KITTITAS COUNTY

TO: All Staff
FROM: Public Works Plan Review Team
DATE: October 17, 2022
SUBJECT: BL-22-00018 Haberman-Silva Survey Review

HABERMAN/SILVA PROPERTIES

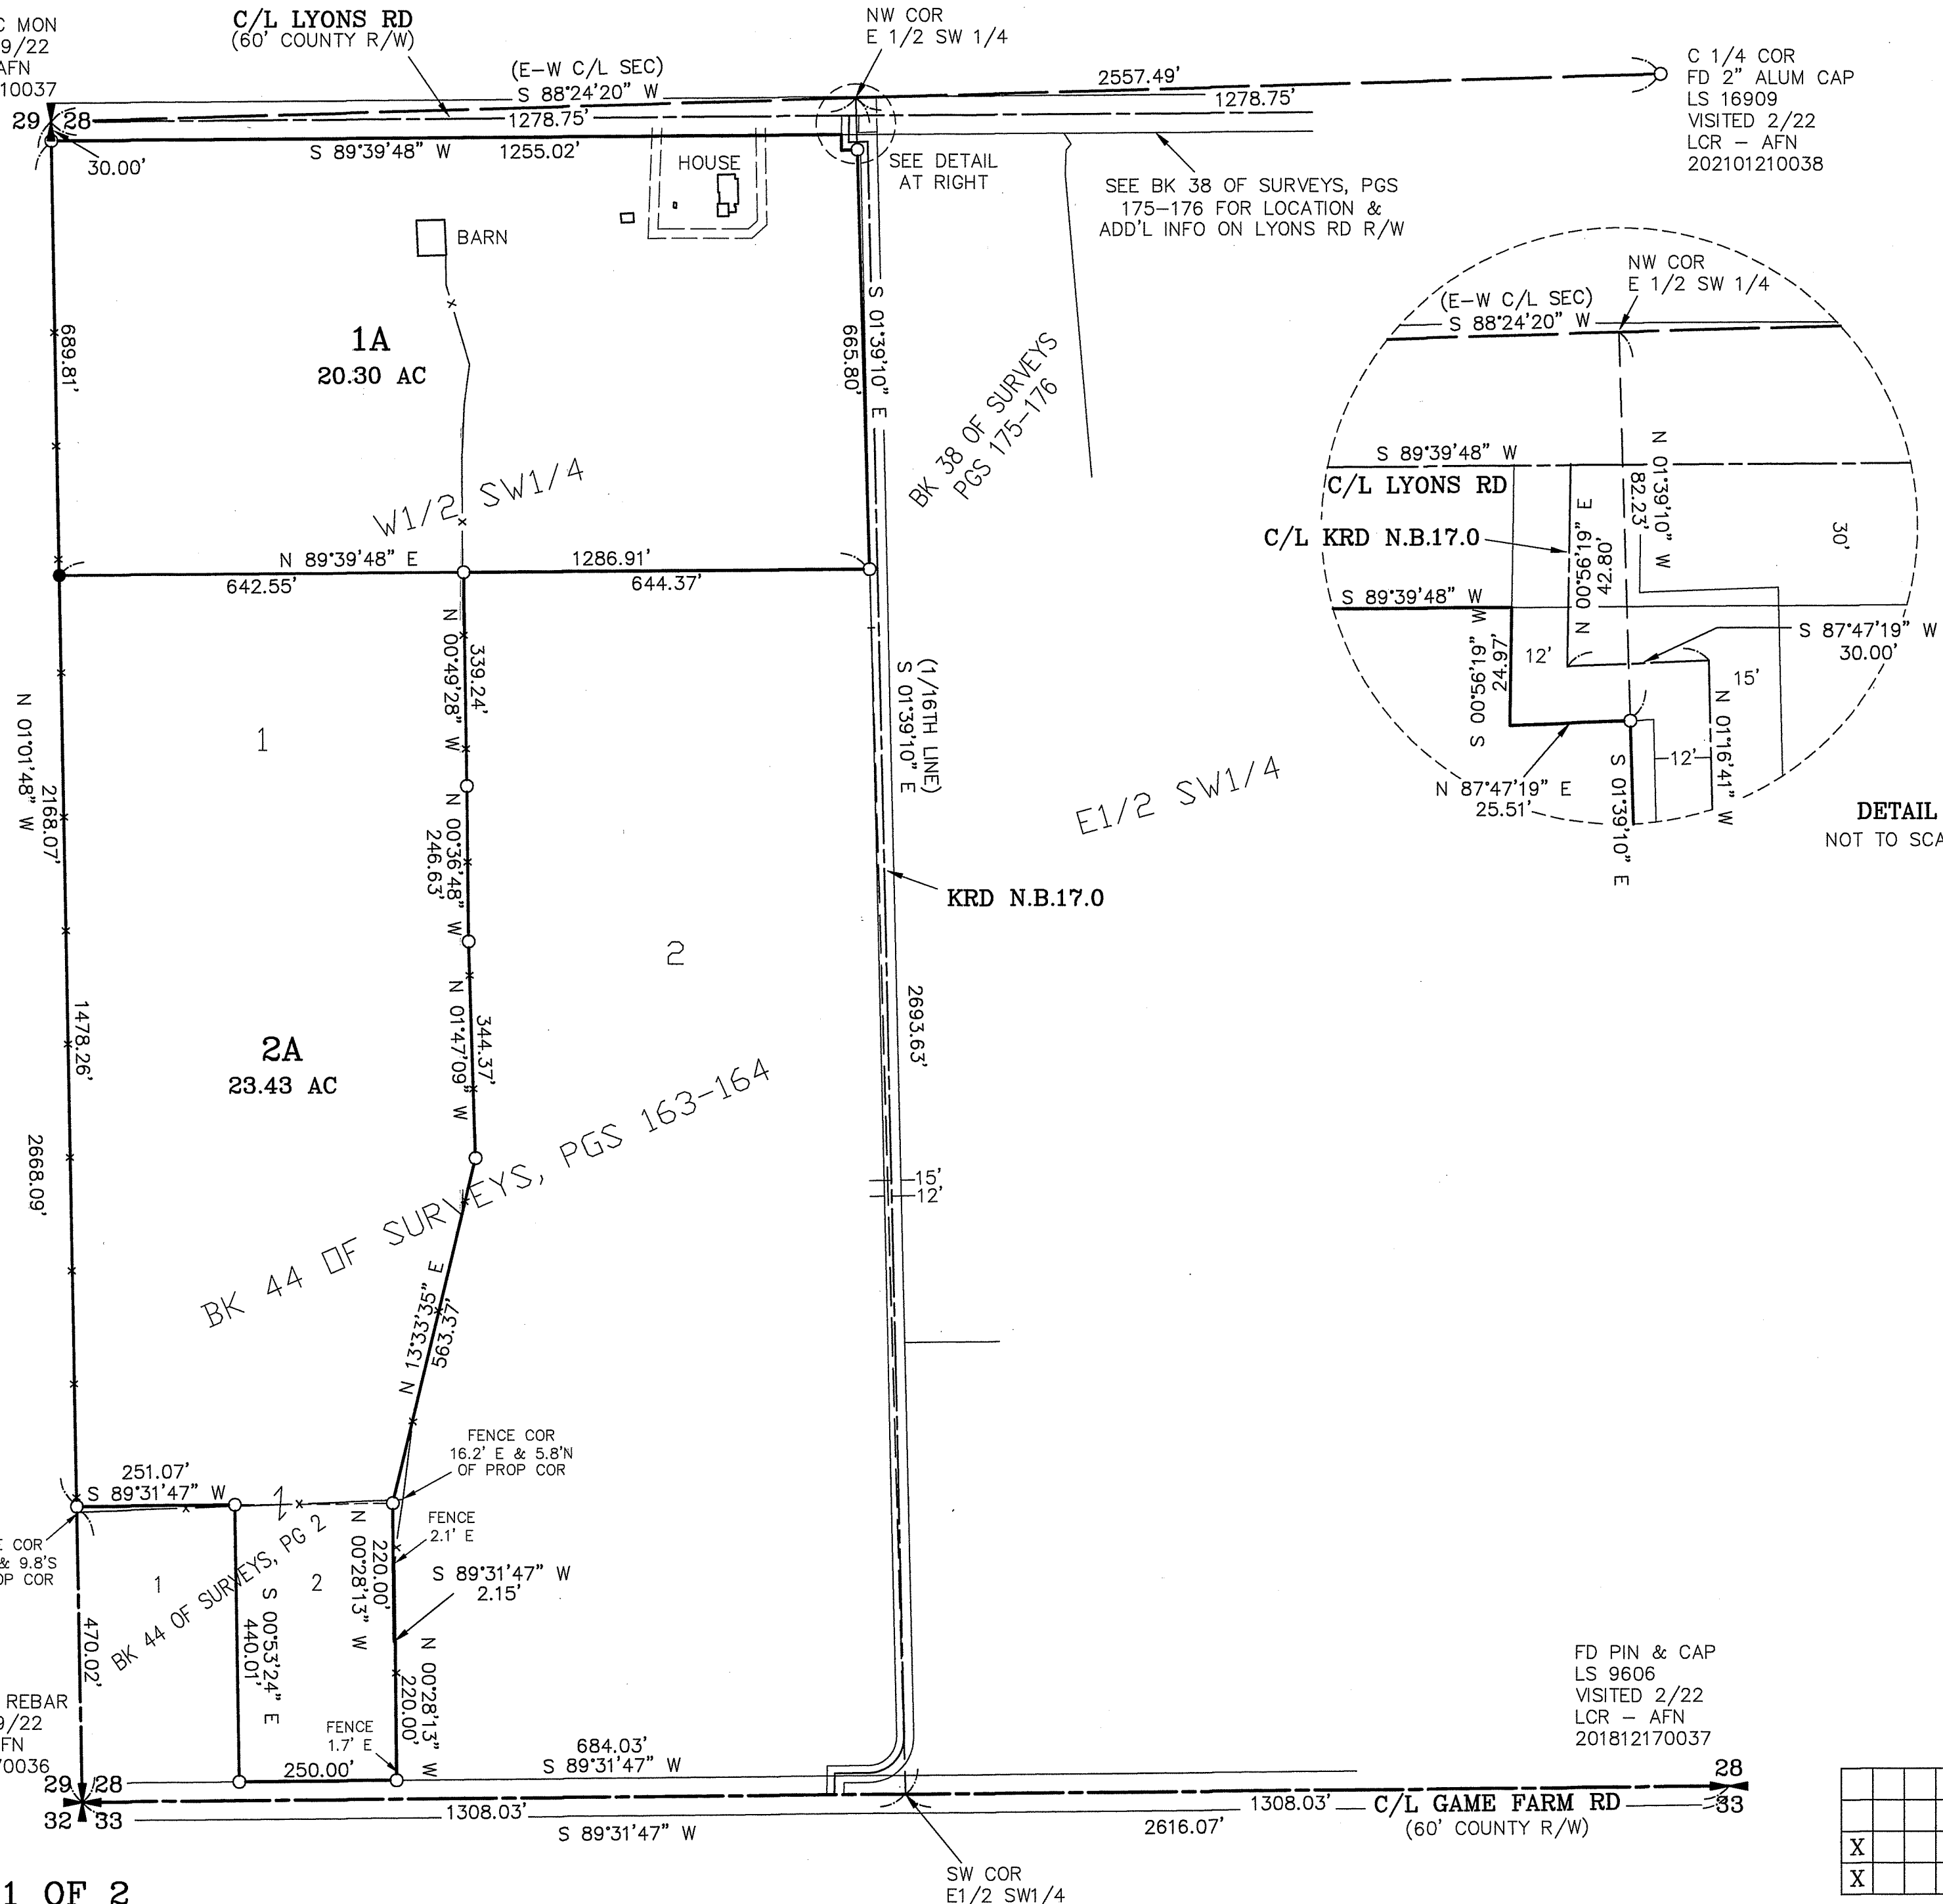
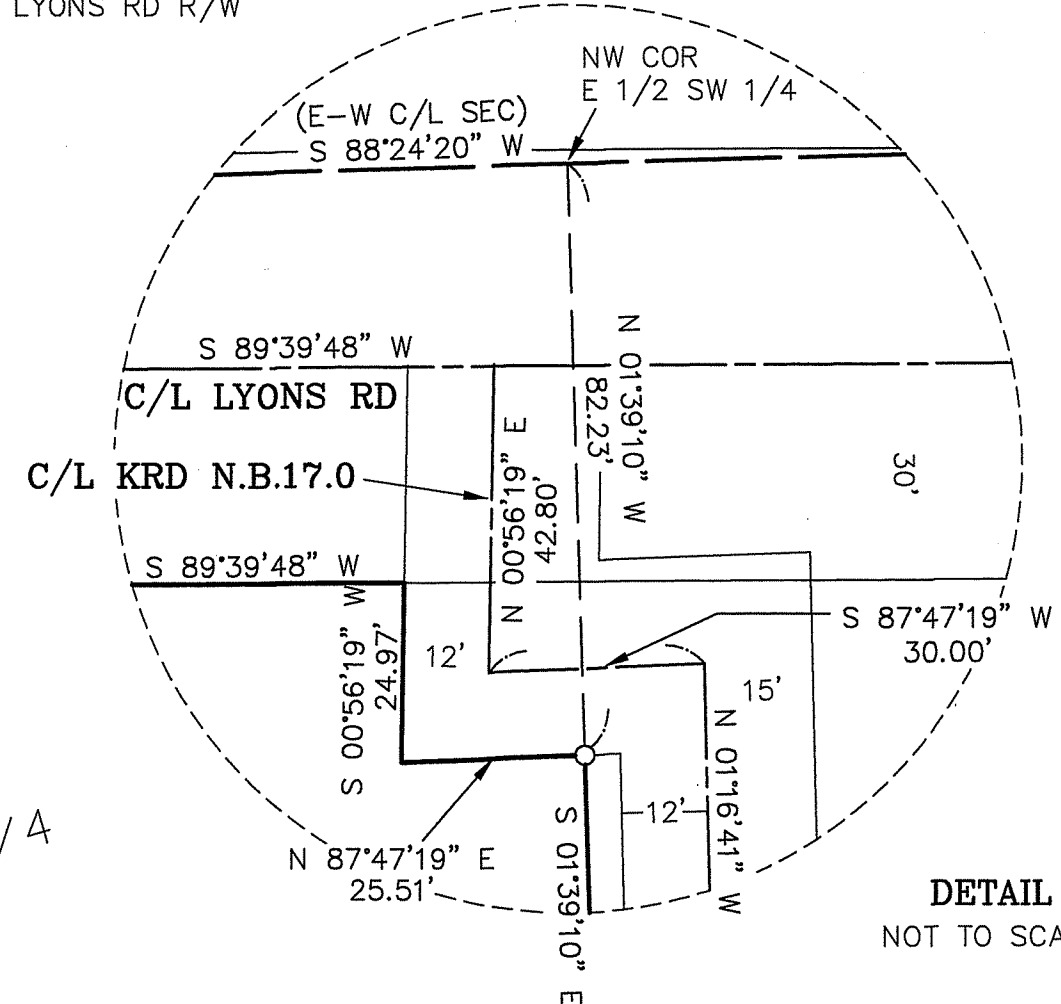
SURVEY	<p>Proposed Changes</p> <ol style="list-style-type: none">1. Show and label Naneum Creek and the Pond (if it is still there). Approximate positions are fine. <p>Of Note (Changes not required)</p> <ol style="list-style-type: none">1. It appears that the parcel to the West may be encroaching or trespassing onto Parcel 1A. If this is the case, the usage limits should be identified and shown.2. It appears inconsistent to show the house and the barn located on the Northern parcel, and not show the house and outbuildings on the Southern parcel.
---------------	---
